Recommendation Report for Lawful Development Certificate for a Proposed Use or Development

REF NO: A/94/12/CLP

LOCATION: Fairway
Ham Manor Way
Angmering

PROPOSAL: Application for a Lawful Development Certificate for a proposed use - rear extension

Ham Manor extension
Block Plans
1:500 @ A4

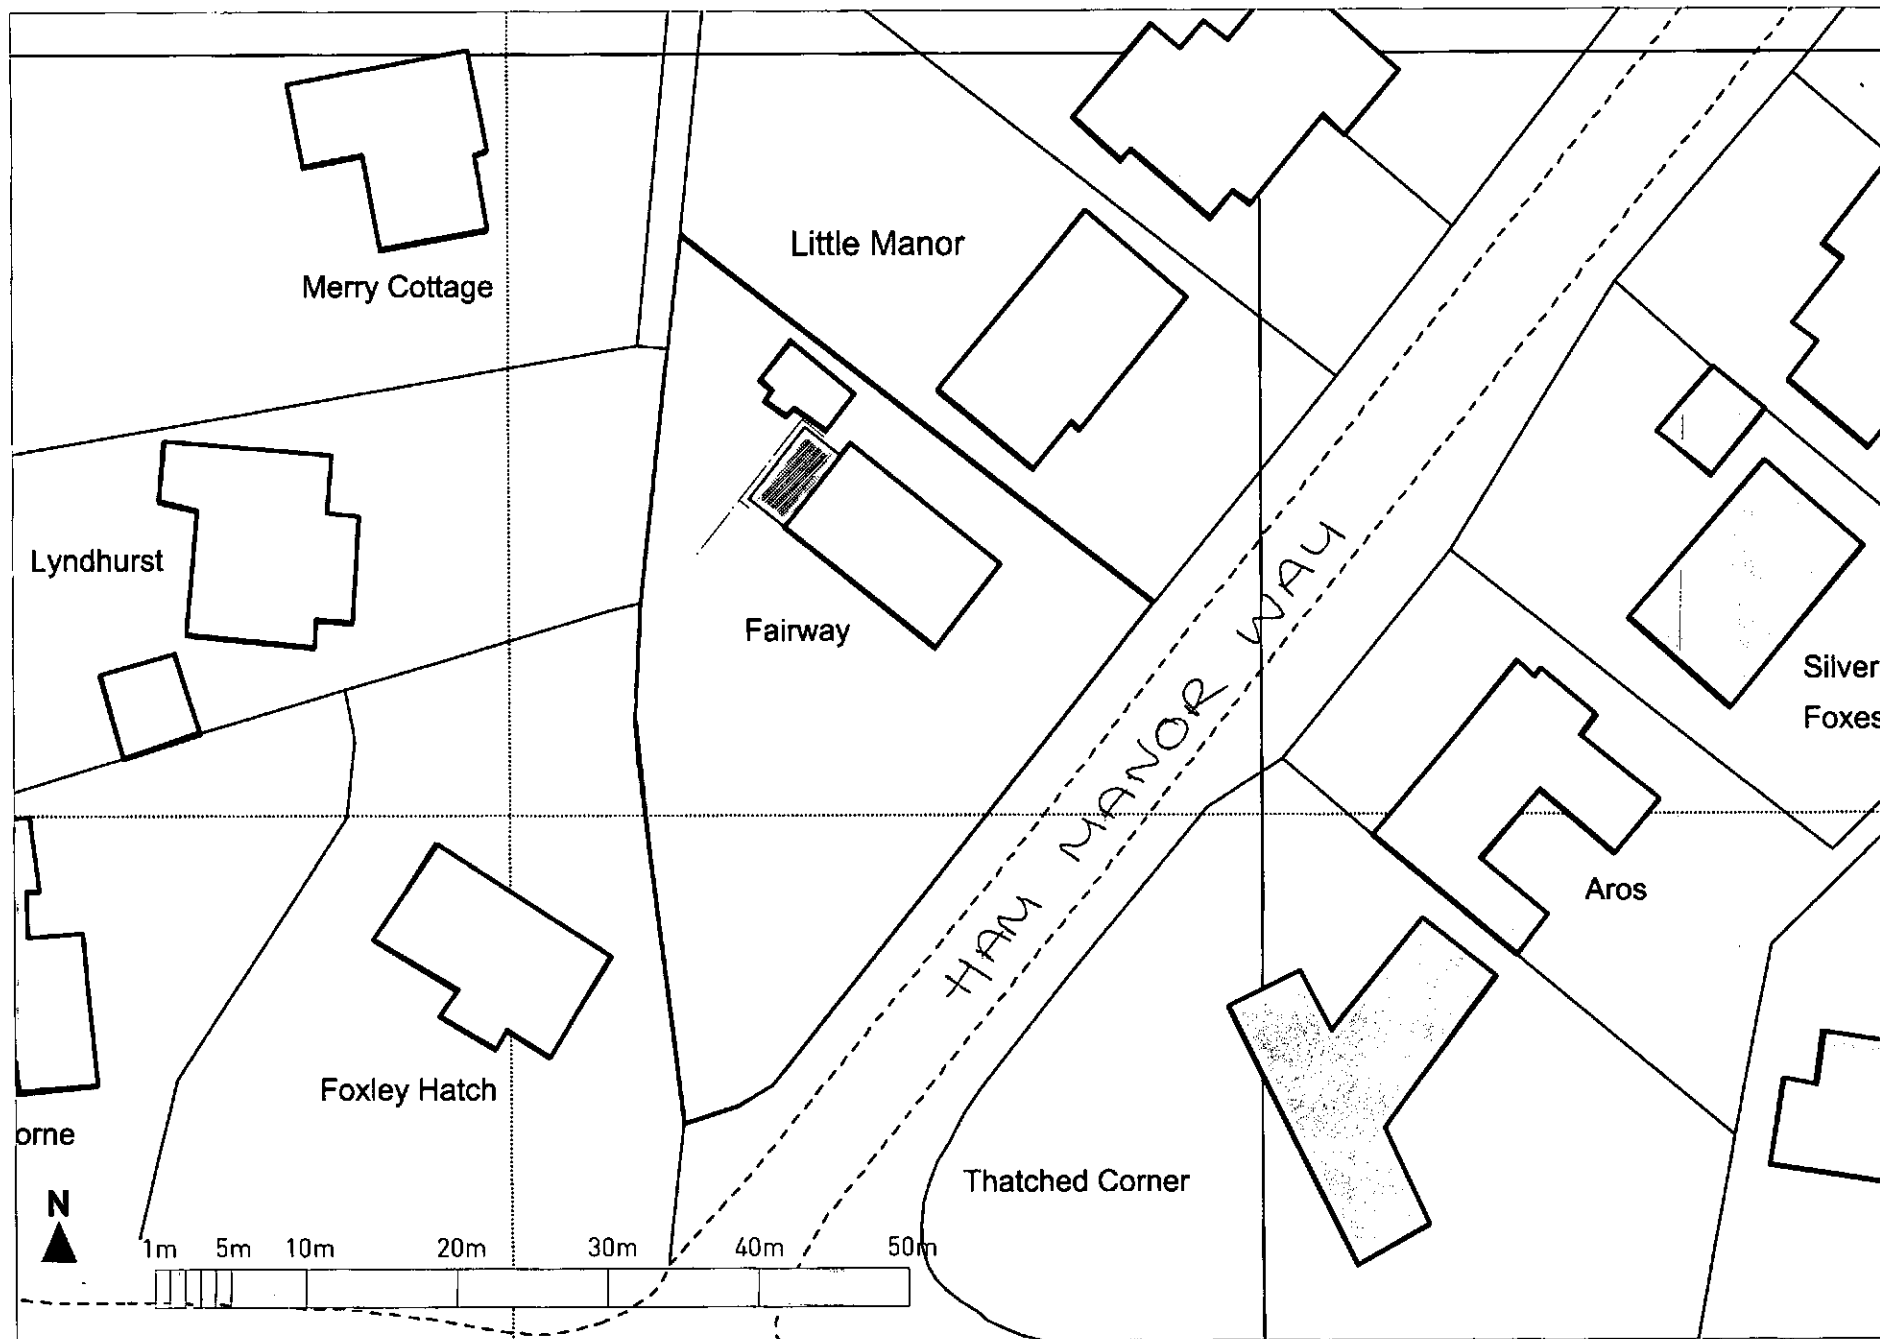
While the frontage of the property facing Ham Manor Way is suggested as being a principal elevation, I find that the south-west elevation facing West Drive would be the principal elevation. It contains a central feature gable with a pair of sloping roof dormers and large principal windows. The proposed development therefore results in a two storey extension to a side elevation of the dwelling, as such the proposal is not permitted development under criteria i and ii of A.1 (h).

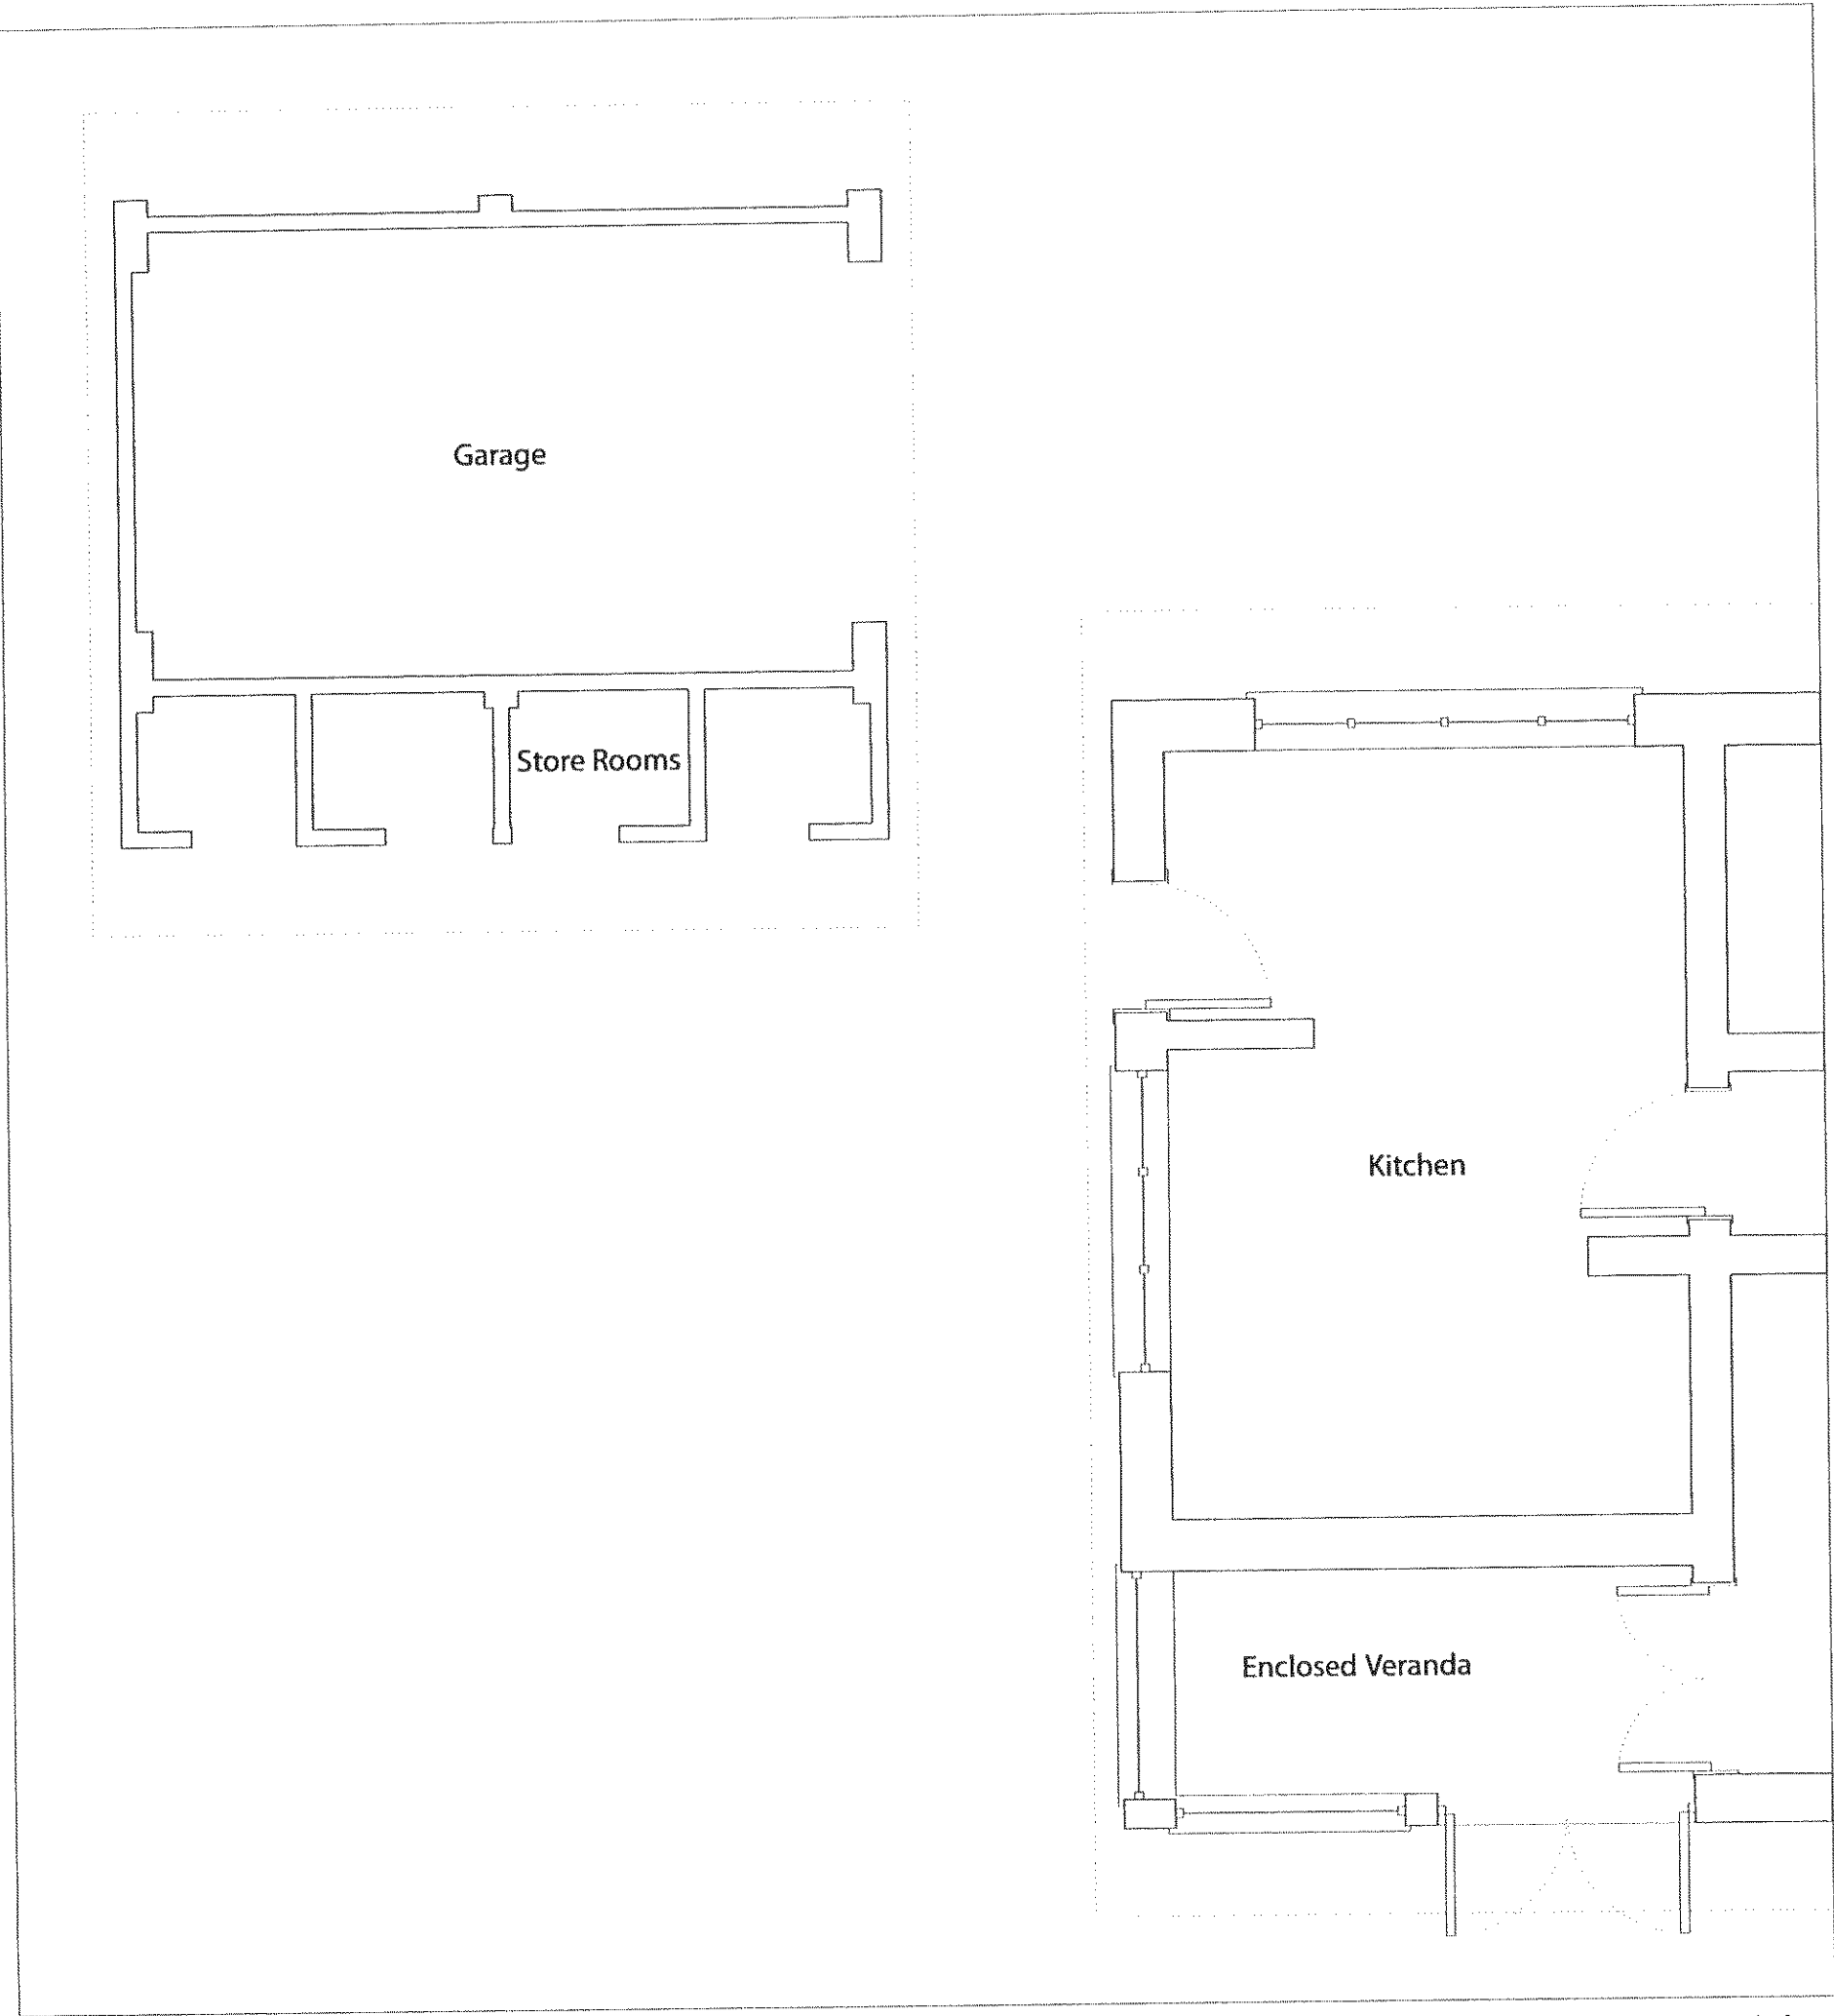
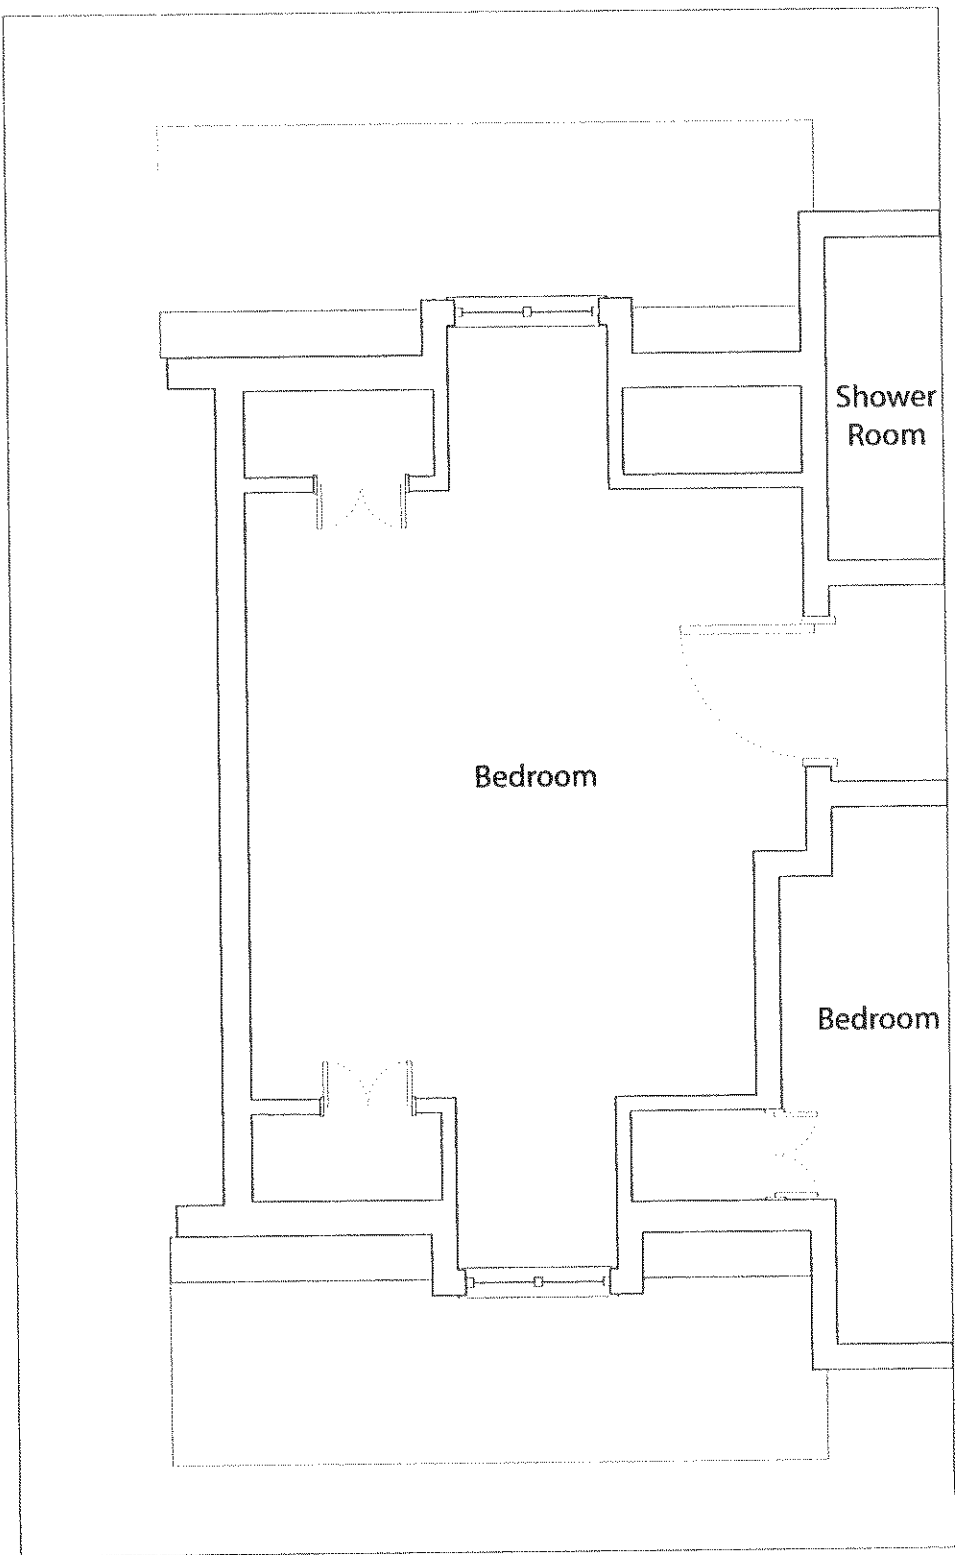
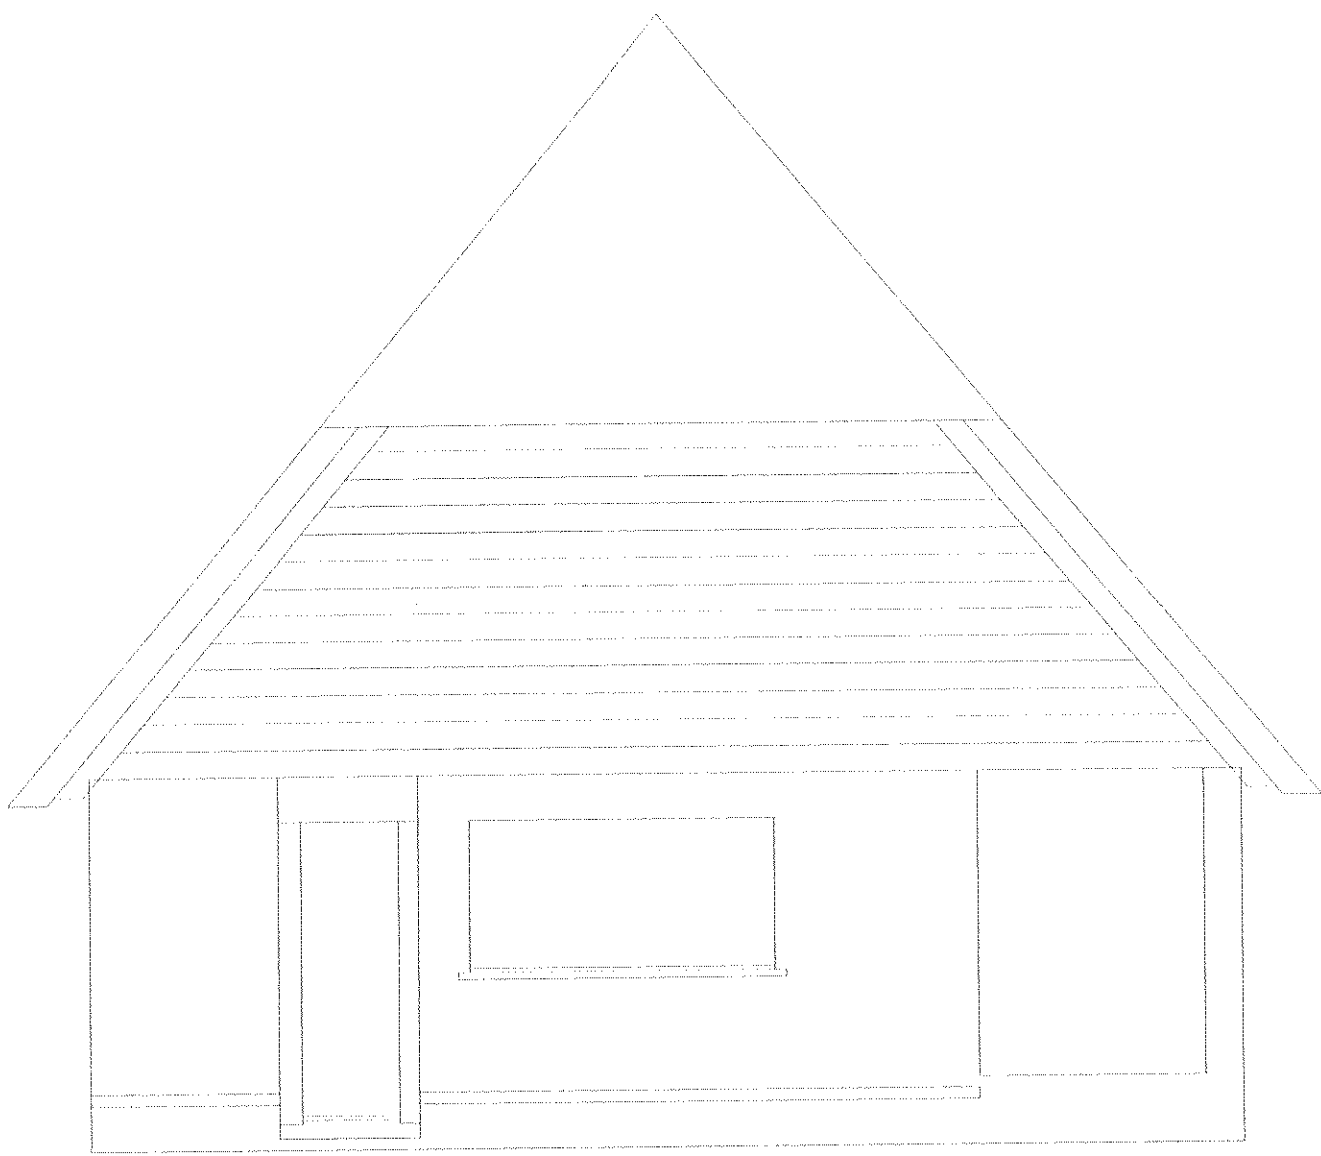
As such the proposal fails to comply in any form with the permitted development allowances; Planning Permission is therefore required.
